Fenwick Solar Project Limited

**Planning Act 2008 – Application for a Development Consent Order for Fenwick Solar Farm**

**Applicant Response to Section 51 Advice Letter dated 29 November 2024**

**Application Ref: EN010152**

ISO A1 594mm x 841mm
Revision: 0 Drawn: AK Checked: JW Approved: MS Date: 2024-10-24
Filename: I:\60698207_Fenwick_Solar_Farm02_Maps\DCO\Dec_2_8_Waterbodies_Plan\EN010152_APP2_8_Water_Bodies_Plan_v0_A1.aprx

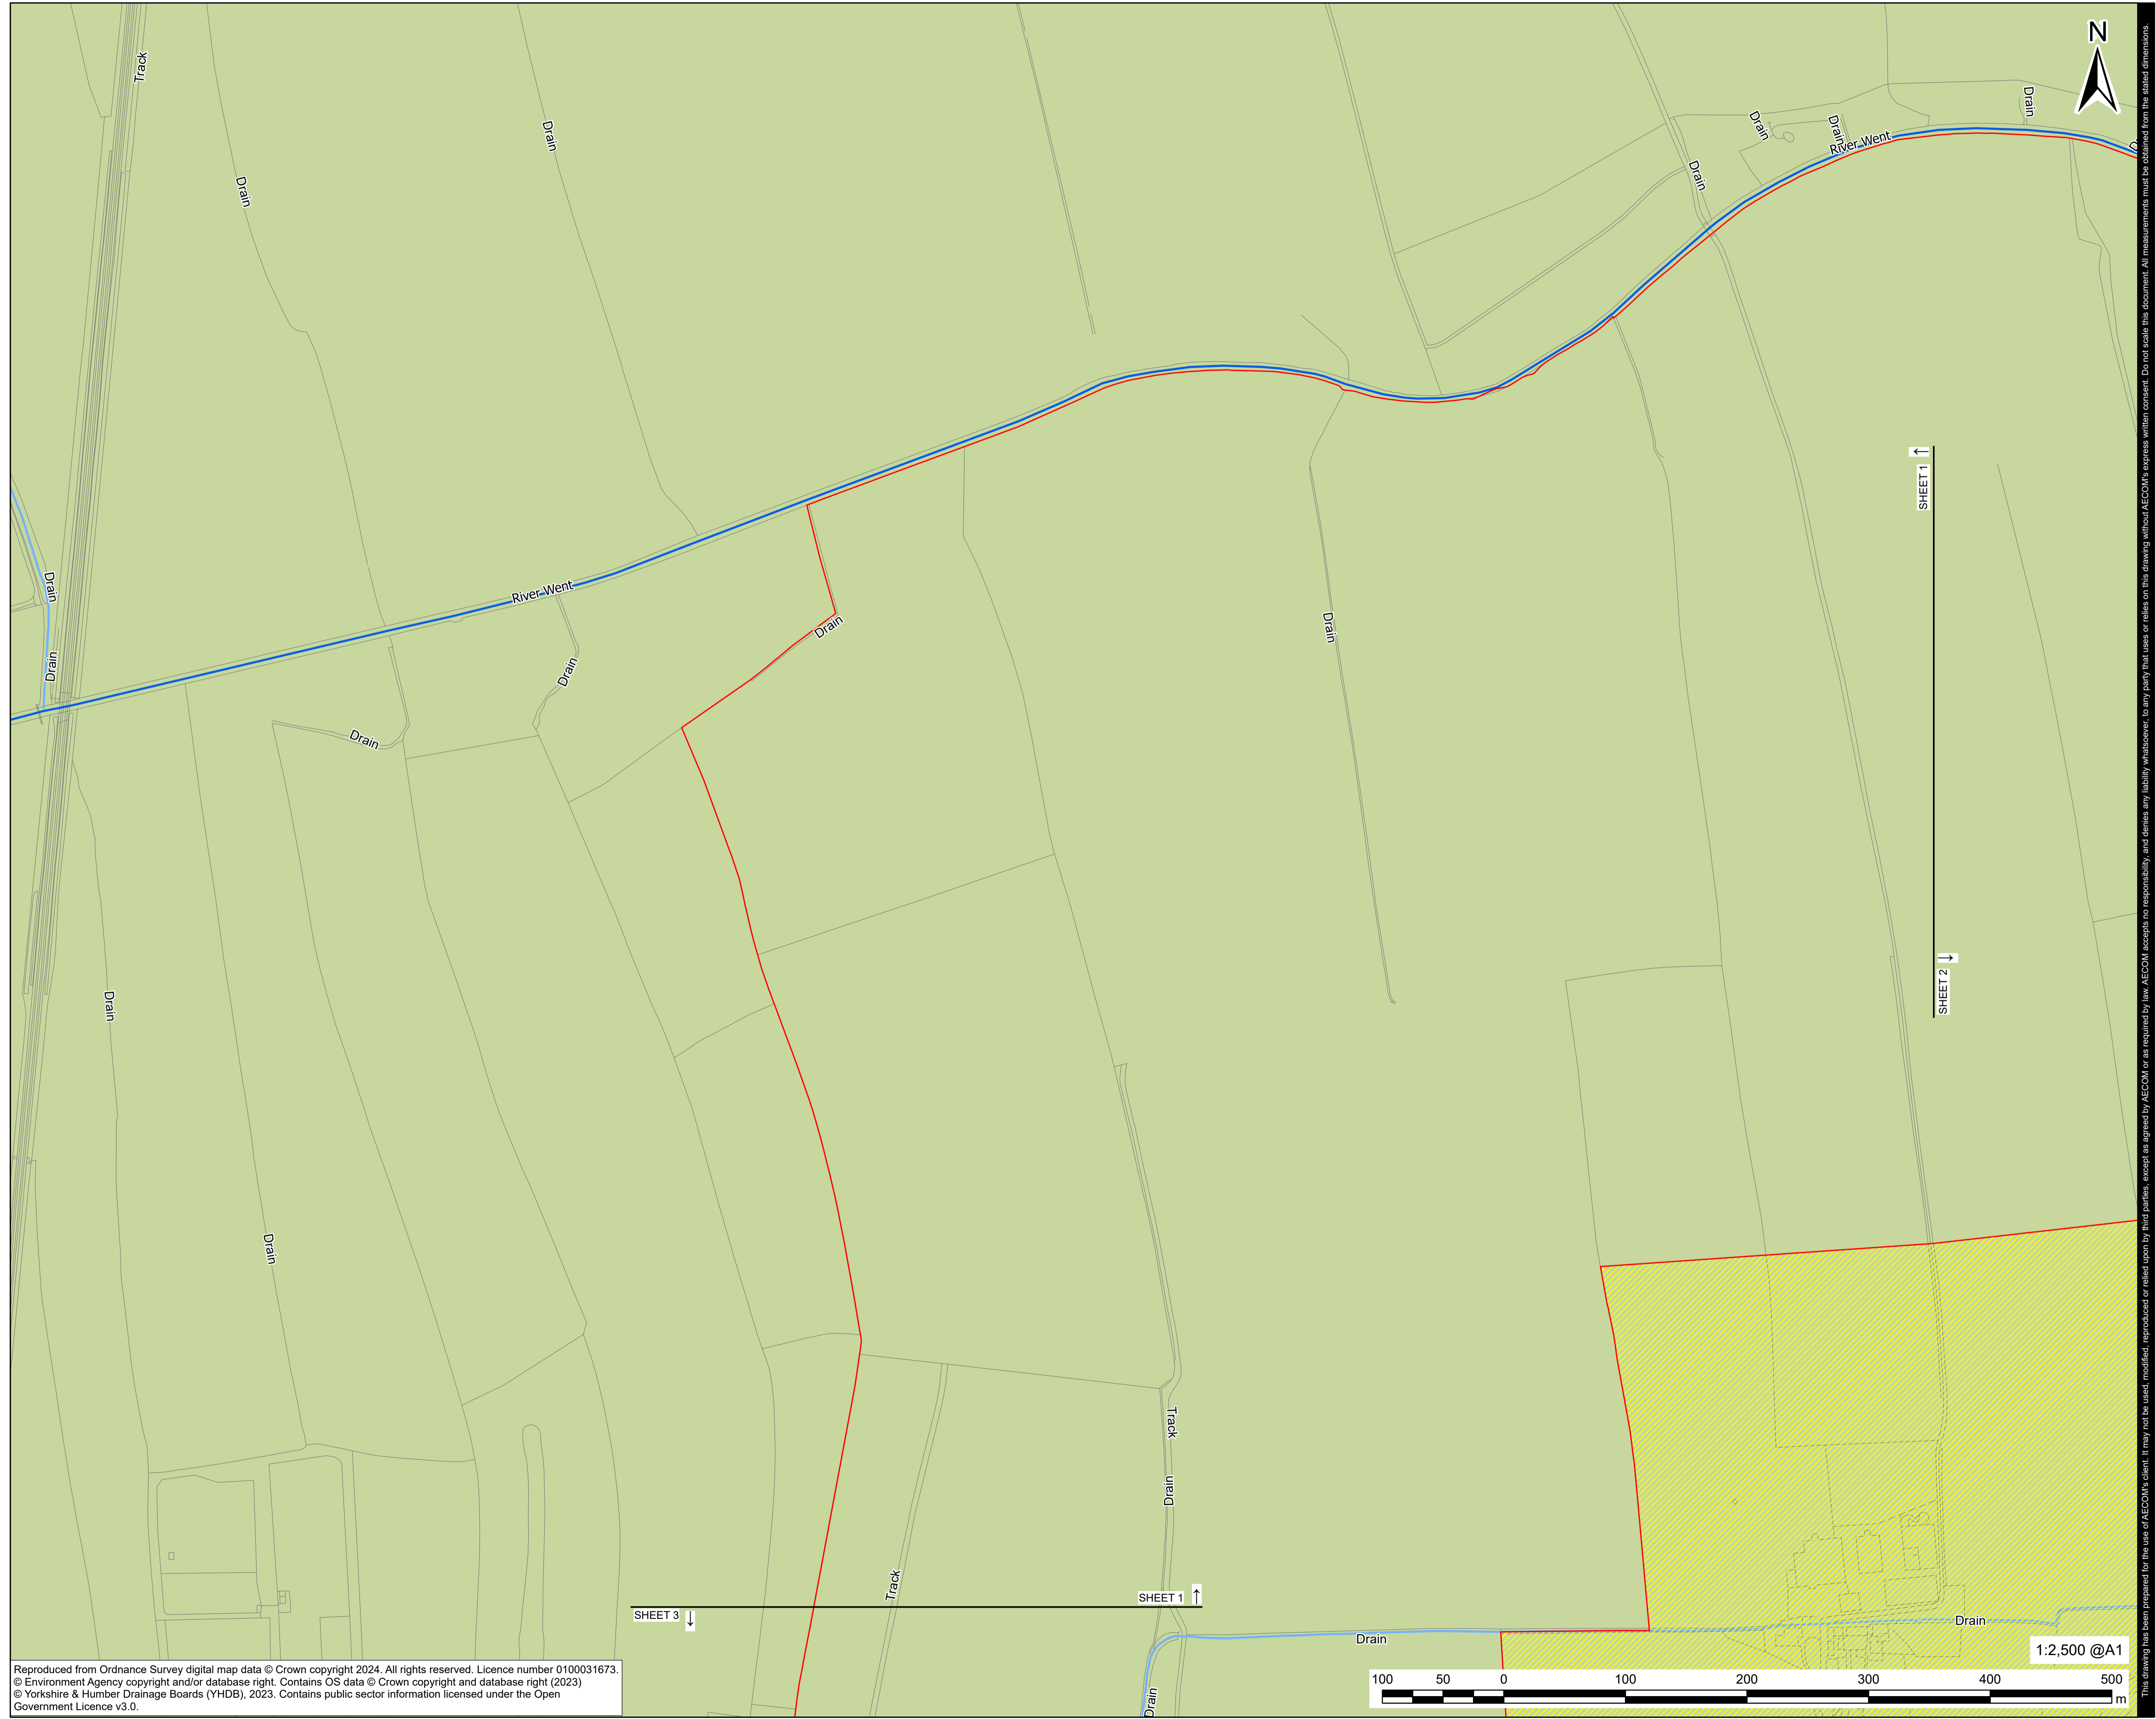
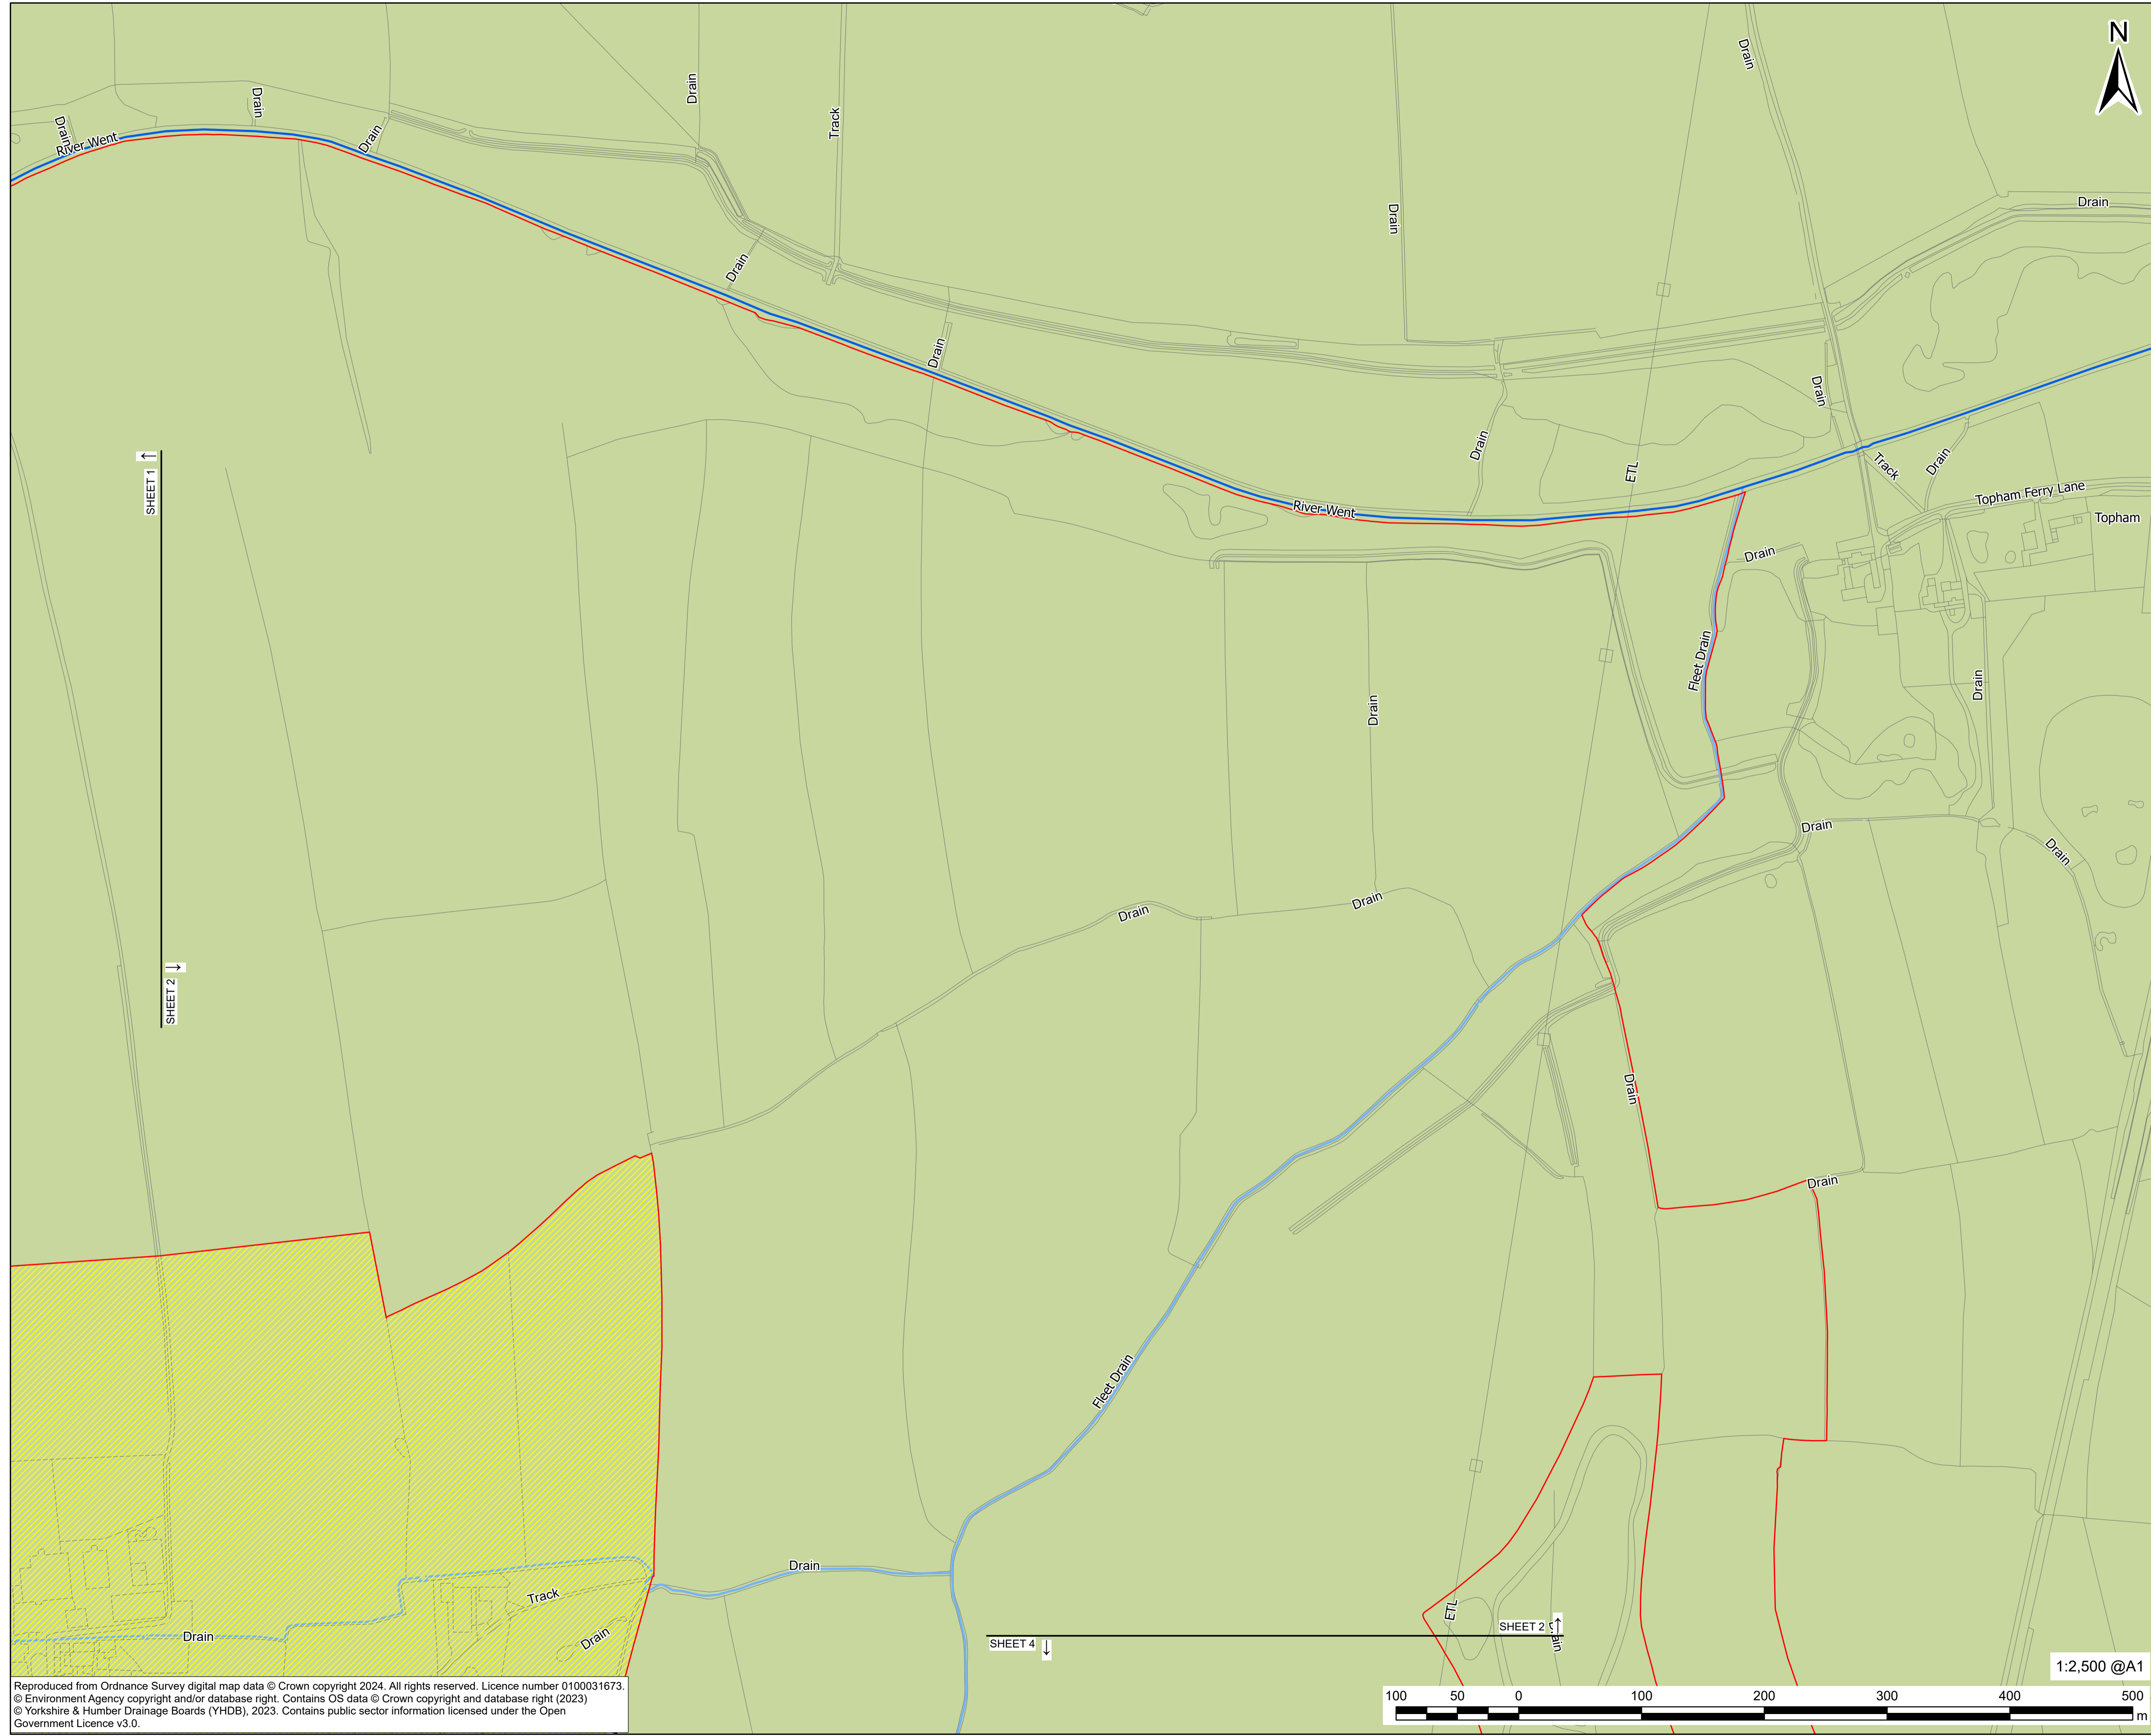
- 1.3.7 The **Waterbodies in River Basin Management Plan [EN010152/APP/2.8]** has been updated by adding missing labels of Ordinary Watercourses that are already identified on ES Fig 9-1 Surface Water Features and Attributes **[EN010152/APP/6.2]**. Also, the updated Plan adopts a lighter blue for Ordinary Watercourses, a darker blue for Main River and the colour of the Aire & Don Sherwood Sandstone layer has been changed from green to orange (noting that orange and blue provides a more accessible palette combination).
